Drafted 28 December 2011

**Planning Application, Ribble Valley District
3/11/0991 Hazelmere, Pimlico Road, Clitheroe**

01254 828060
Public Realm Ribble Valley
LCC Environmental Services East

3804 - 10 A

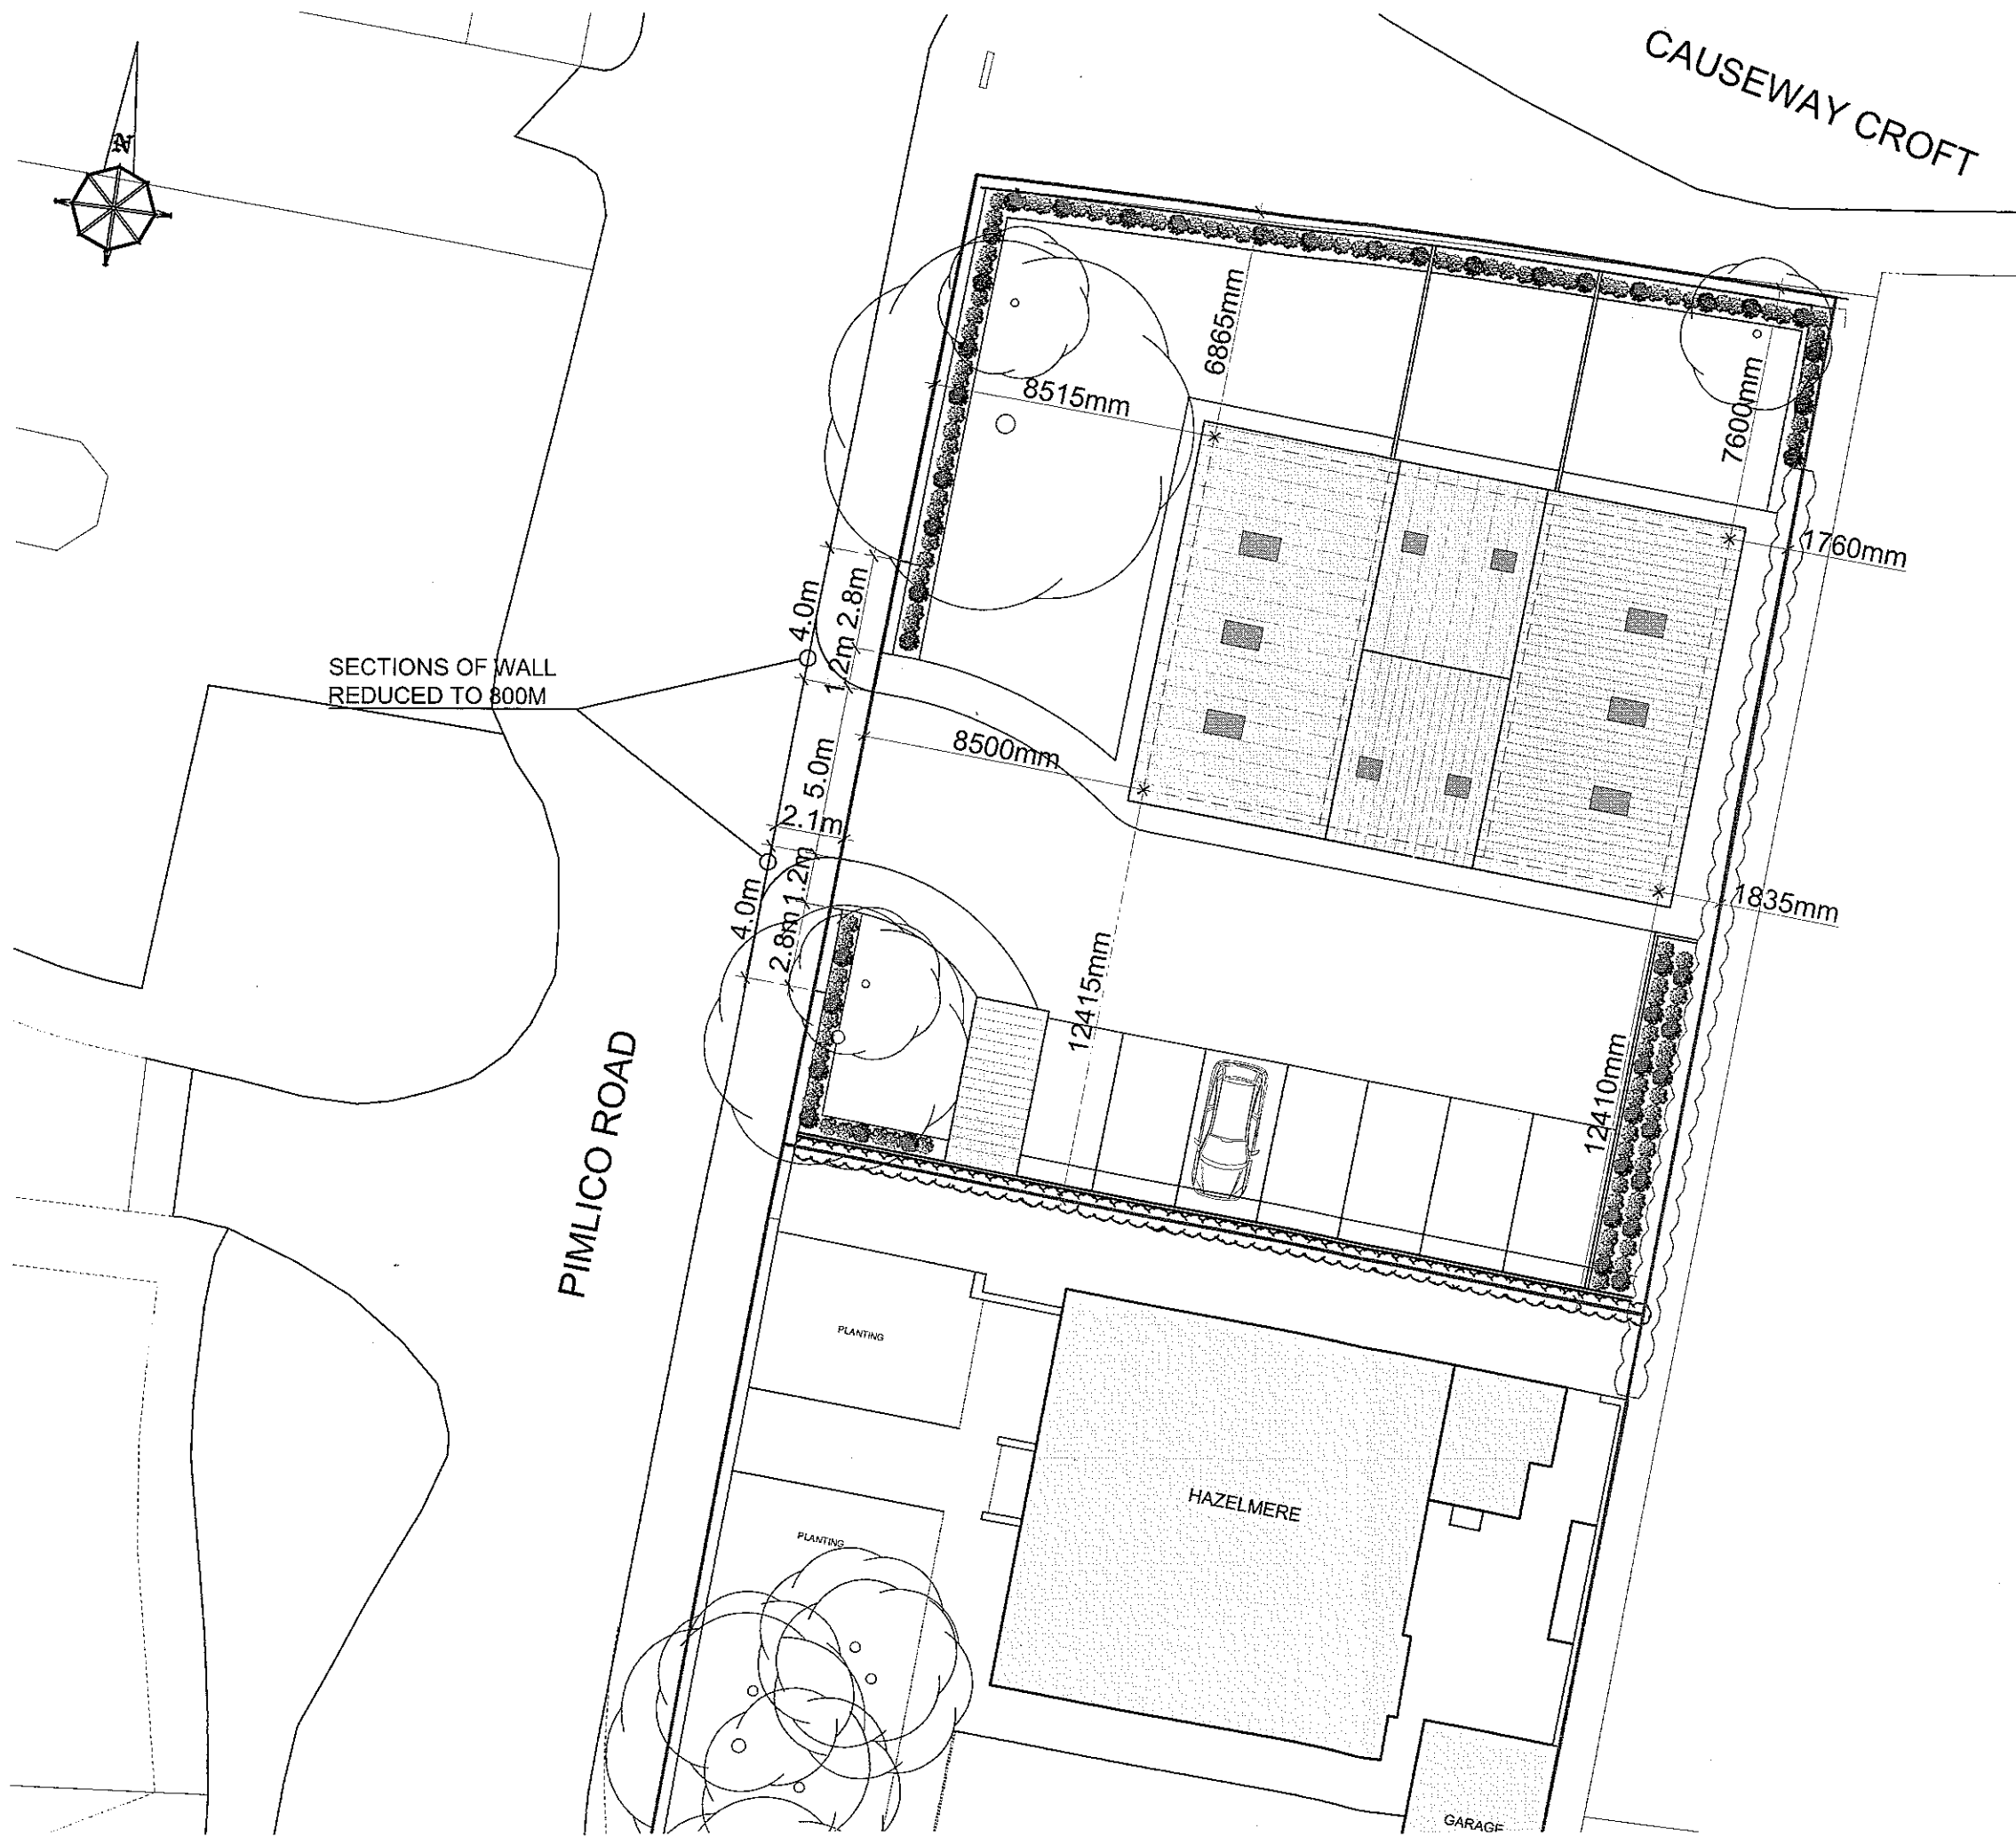
The proposal for three new residential units requires the creation of a new vehicular access on Pimlico Road. With the proposed location of the vehicular access I would welcome a clear indication on a suitable site plan that a minimum sightline of 40m by 2.4m can be secured. As there is already an indication that the boundary wall will be lowered to a maximum of 0.8m for a distance of 4.0m, this should be a formality. The present annotation on the site plan indicating the reduced height for the boundary wall appears to show the wall immediately to the back of the carriageway rather than to the back of the footway.

There is approximately 31m separation between the new access and Causeway Croft and this is adequate to insure that there is no direct interaction between their respective turning movements, in this instance.

The car parking provisions within the site, with 7 spaces for 3 residential units, and the manoeuvring space available are satisfactory to allow for the safe movement of vehicles to and from the site in a forward gear.

In order to maintain visibility at the access for passing traffic, emerging traffic and pedestrians, it would be beneficial to introduce a length of prohibition of waiting along the frontage. I propose a prohibition of waiting at any time that runs along the east side of Pimlico Road from a point 8m south of the centreline of the access for a distance of 26m in a northerly direction. This will link with an existing length of prohibition at Causeway Croft to provide improved visibility for motorists emerging from both junctions.
